Subject: Attention Planning Support Team CORRECTION in Comments acknowledgement for 22/00336/F

"Regarding 22/00336/F 1 Meadow Crest Cottages, Burdrop.

Existing & Proposed
 Site Plans

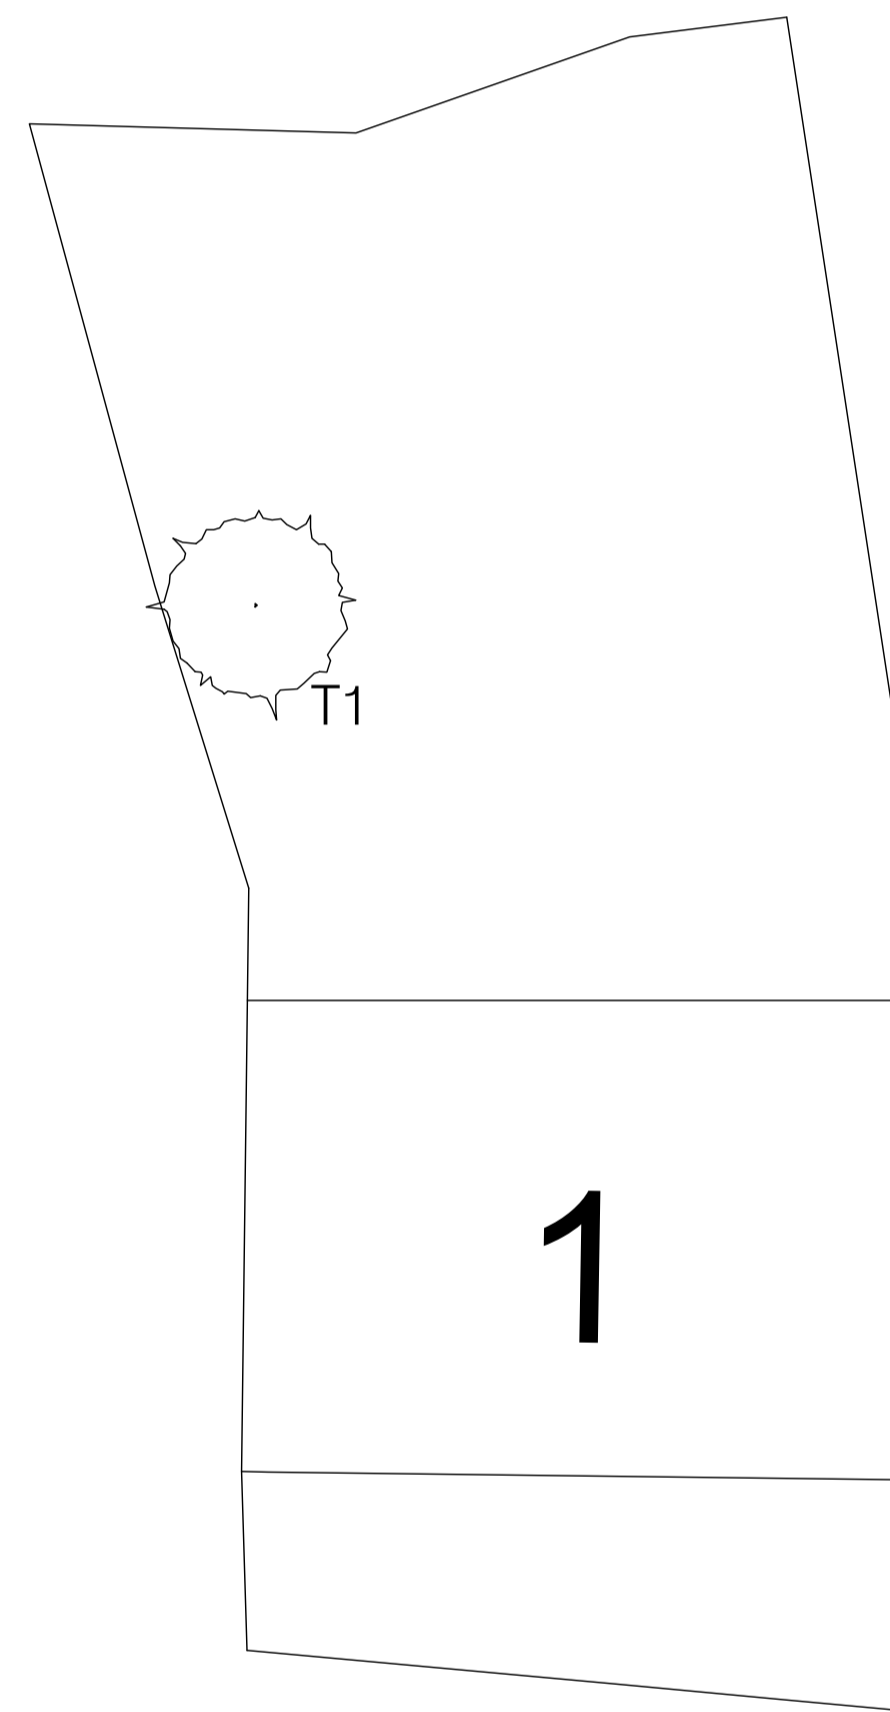
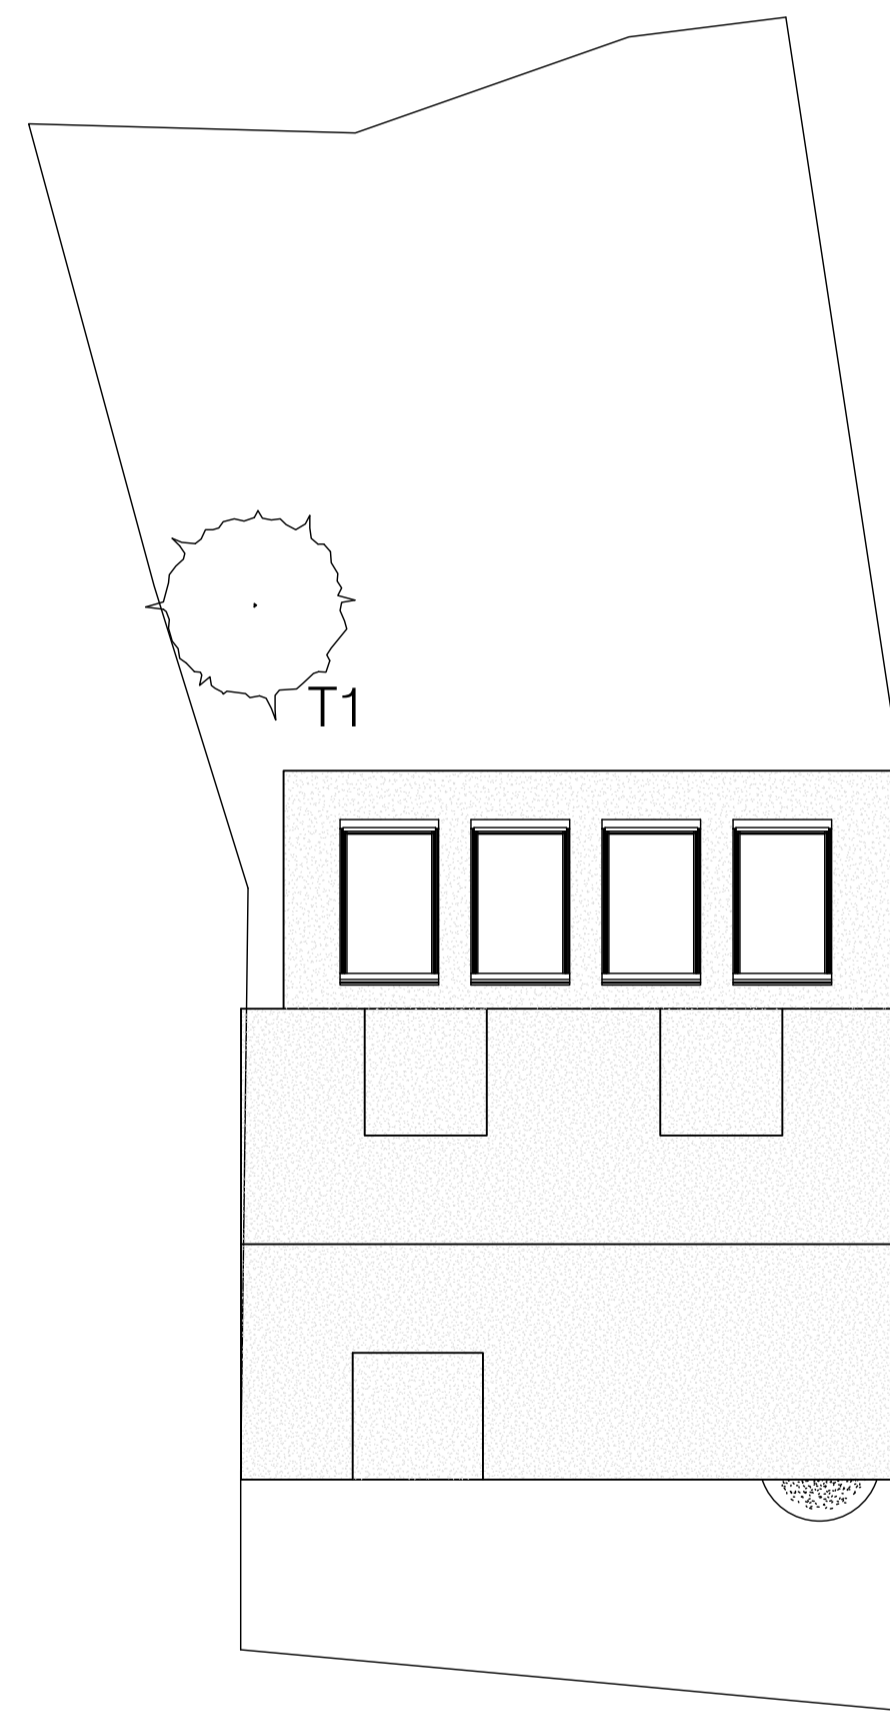
As the submission of the local parish council has already highlighted, the siting of the proposed canopy would cause run-off to fall directly onto the narrow frontage of the adjoining property. The limited drainage system that actually runs underneath the property, is shared between the two - a further complication. Indeed, any significant construction works would similarly impact on the same property. In common with all the other cottages in the row, it has no back access, which is already problematic for the provision of mains services and the maintenance of all the adjoining properties in the row; and there is no parking space in what is a narrow village lane either for any builder's vehicles, or for any additional cars.
